**RE: Bosque Antigua Preliminary Plat
Justifications for Easement Vacation and Construction of Cul-de-Sac
Existing Legal: Tract 2A and a Portion of Tract 3, Kelly Tracts
Zone Atlas Map: H-12**

Isaacson & Arfman, acting as agents for the Developer of the above referenced site located west of Gabaldon Rd. and south of I-40 is providing the following response to the comments provided by City Planning.

PROPOSED EASEMENTS

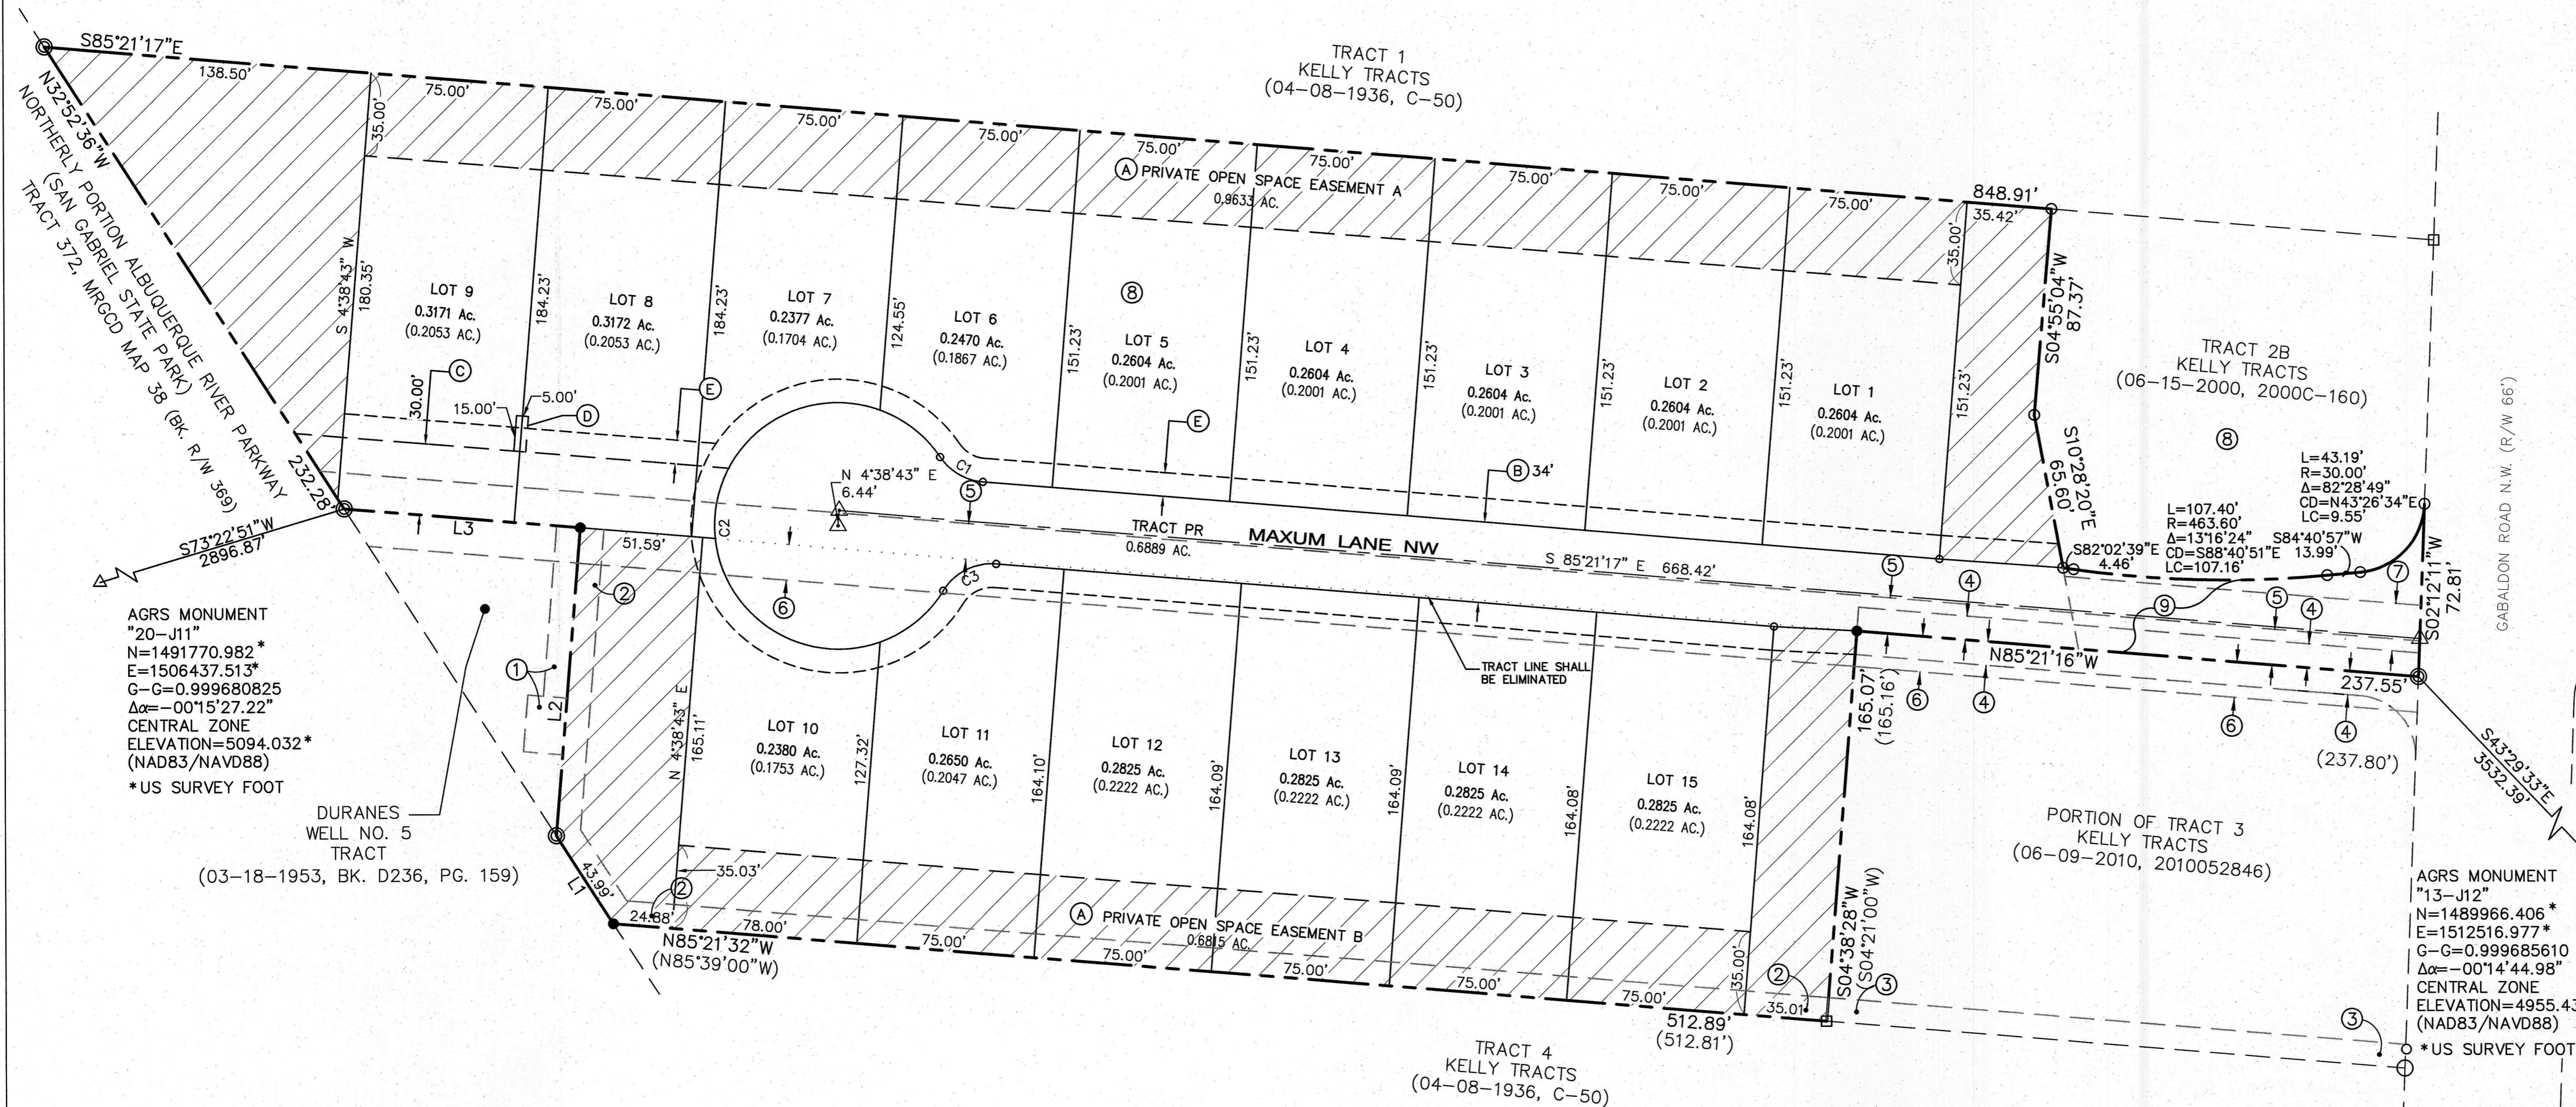
- (a) The public welfare does not require that the public easement be retained.
- (b) There is a net benefit to the public welfare because the development made possible by the vacation is clearly more beneficial to the public welfare than the minor detriment resulting from the vacation, and there is no convincing evidence that any substantial property right is being abridged against the will of the owner of the right.

- (a) The existing easements will be replaced with new easements and some easements will no longer be needed.***
- (b) Some of the poles and overhead lines will be eliminated and utilities installed underground, thereby making the property more aesthetically pleasing***

MAXUM LANE CUL-DE-SAC
SCALE: 1"=5'

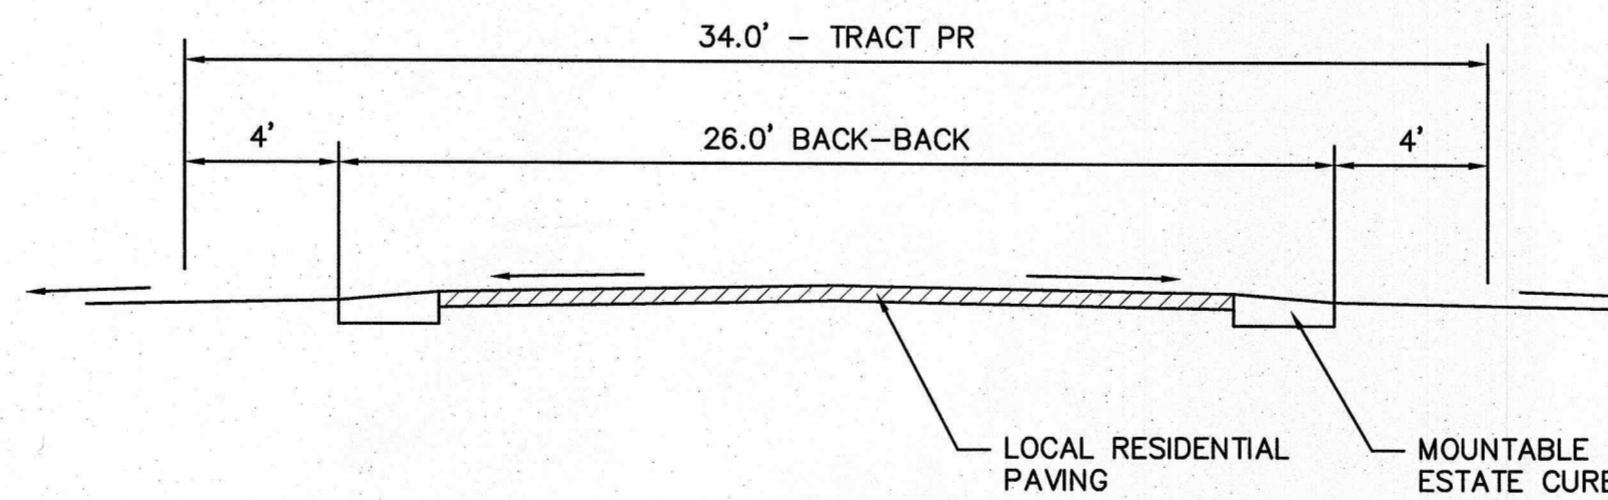
1. Cul-de-sacs are allowed where necessary to avoid those types of sensitive lands listed in Section 14-16-5-2(C), or where vehicular safety factors make a connection impractical, including but not limited to size or shape or lots, topography, surrounding development patterns, and physical characteristics.
2. Permanent stub streets are allowed only where a connection to an existing street and a future road extension is not possible or feasible. Where allowed, stub streets are limited to 150 feet in length.

- 1. The shape of the property is long and narrow, and there is no room for a street looping back to Gabaldon Rd.***
- 2. There is no existing road where a connection or future road extension could be made—City open space (Bio Park) is located west of the site. The cul-de-sac meets requirements (96' dia.) for a fire truck turnaround per the International Fire Code.***

**TYPICAL LOT DIMENSIONS
AND SET BACKS**
SCALE: 1"=40'

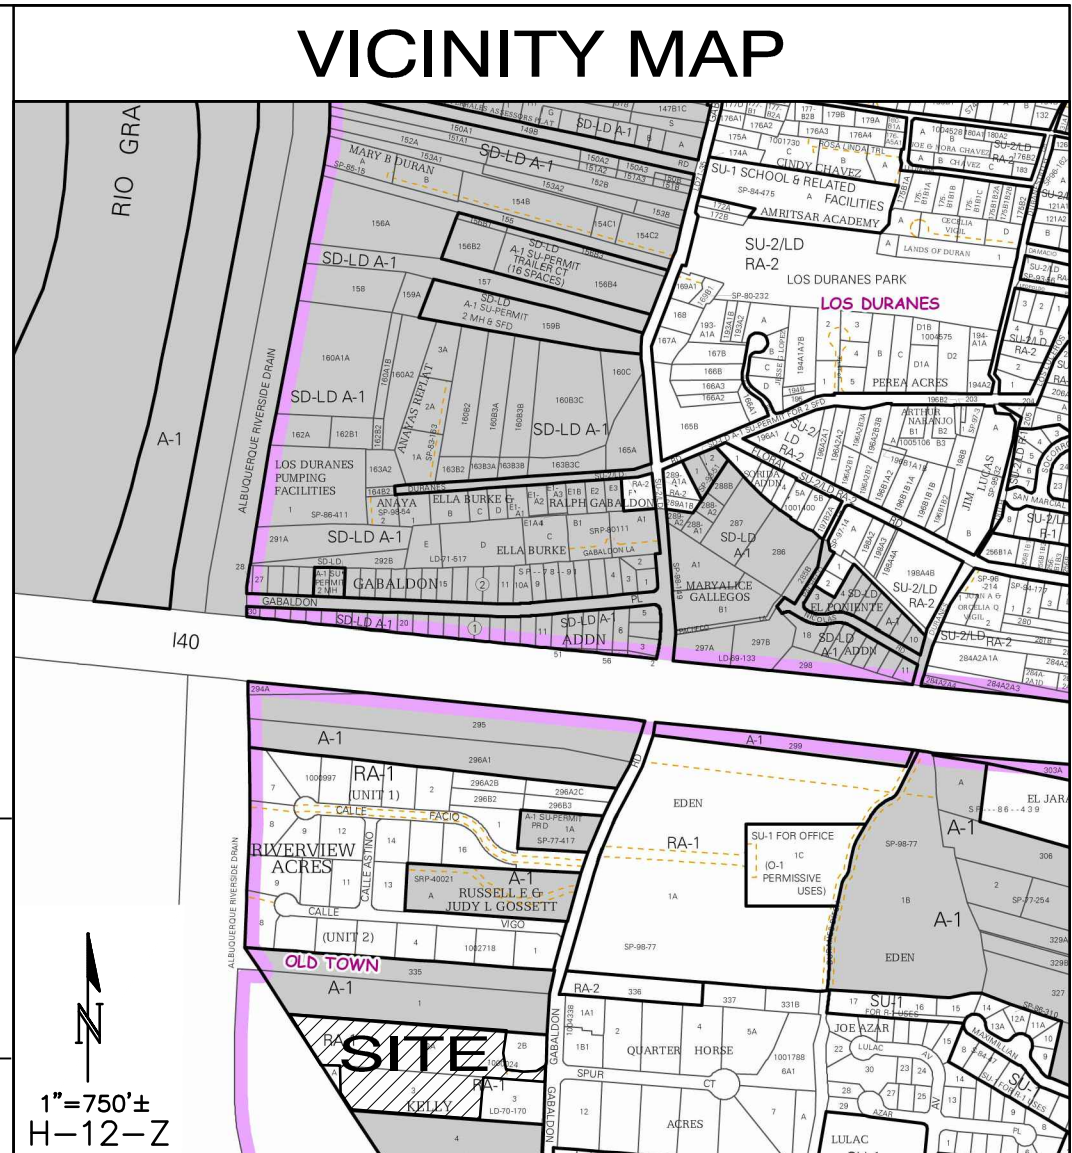
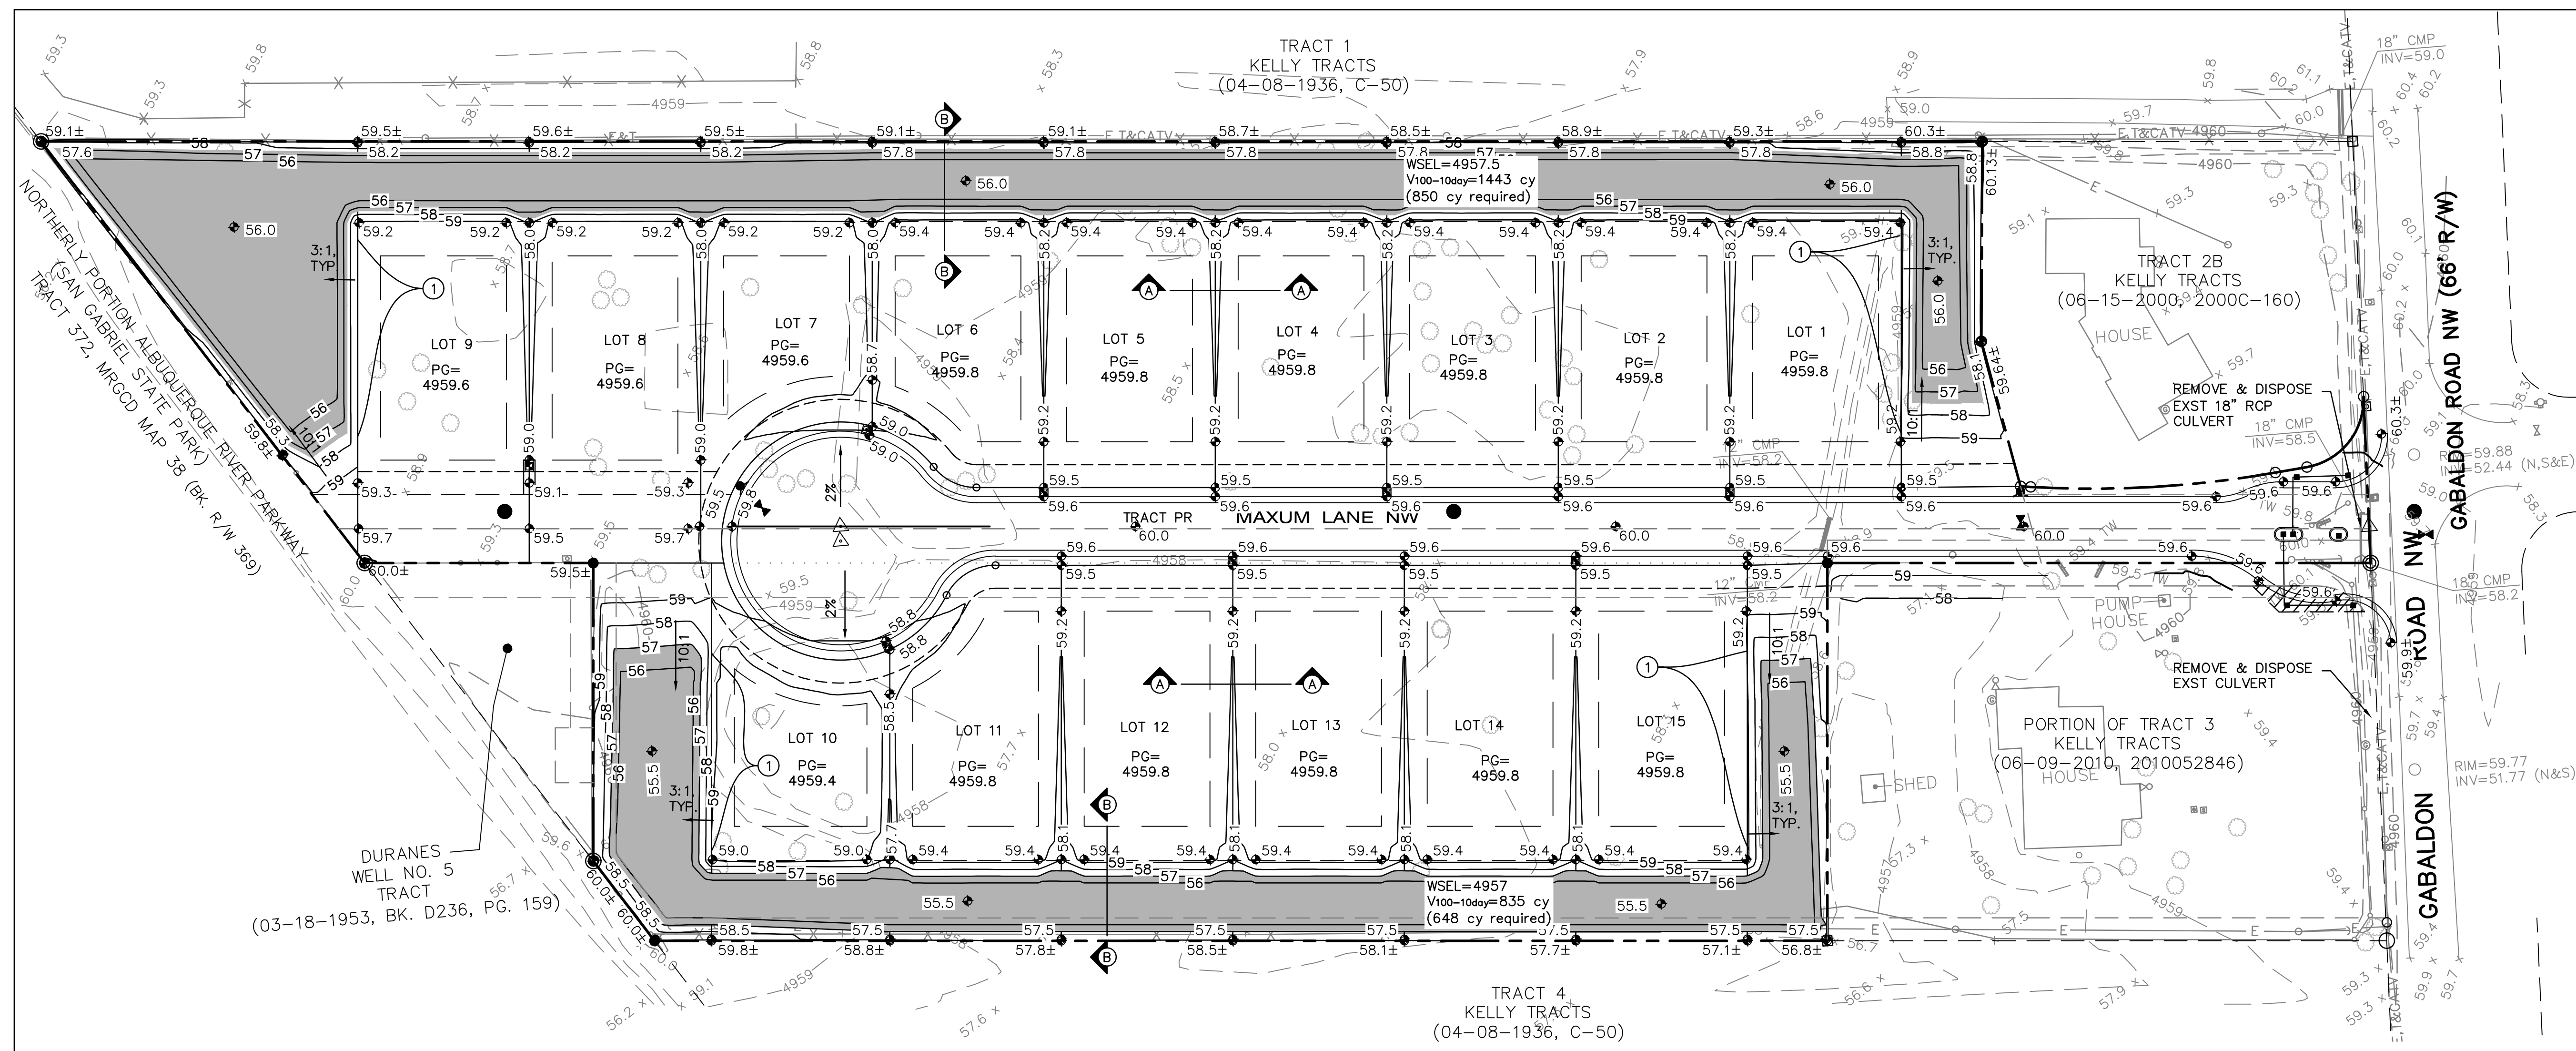
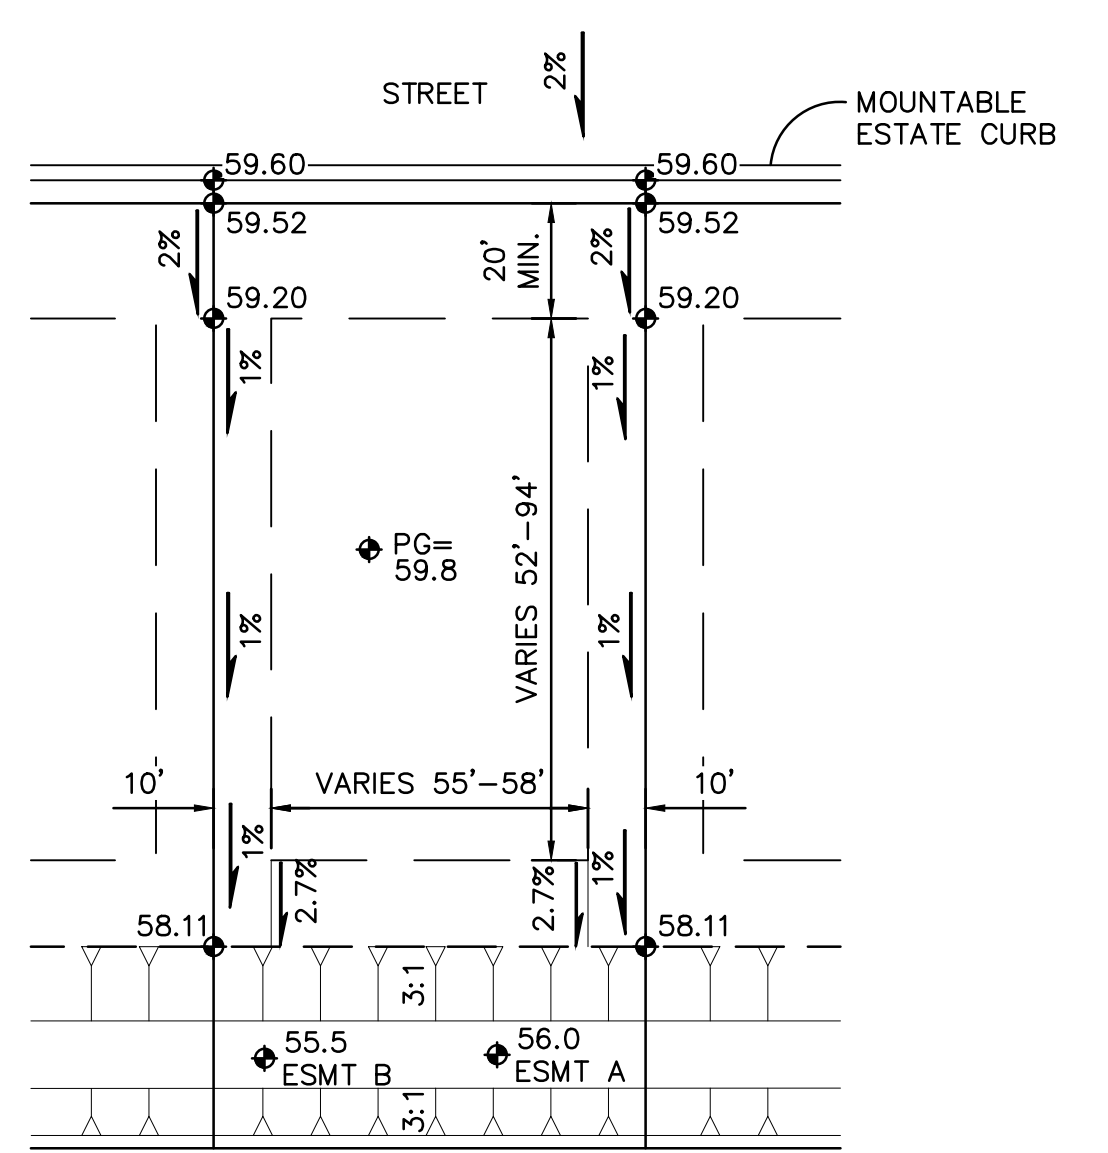
- Reference to open space corrected to “private common open space”.
- Tract designations and areas were added.
- Setback detail on sheet 2 of preliminary plat was eliminated. All setback dimensions will be shown on the site plan.
- See below for justifications for the easement vacation and cul-de-sac construction per the IDO.
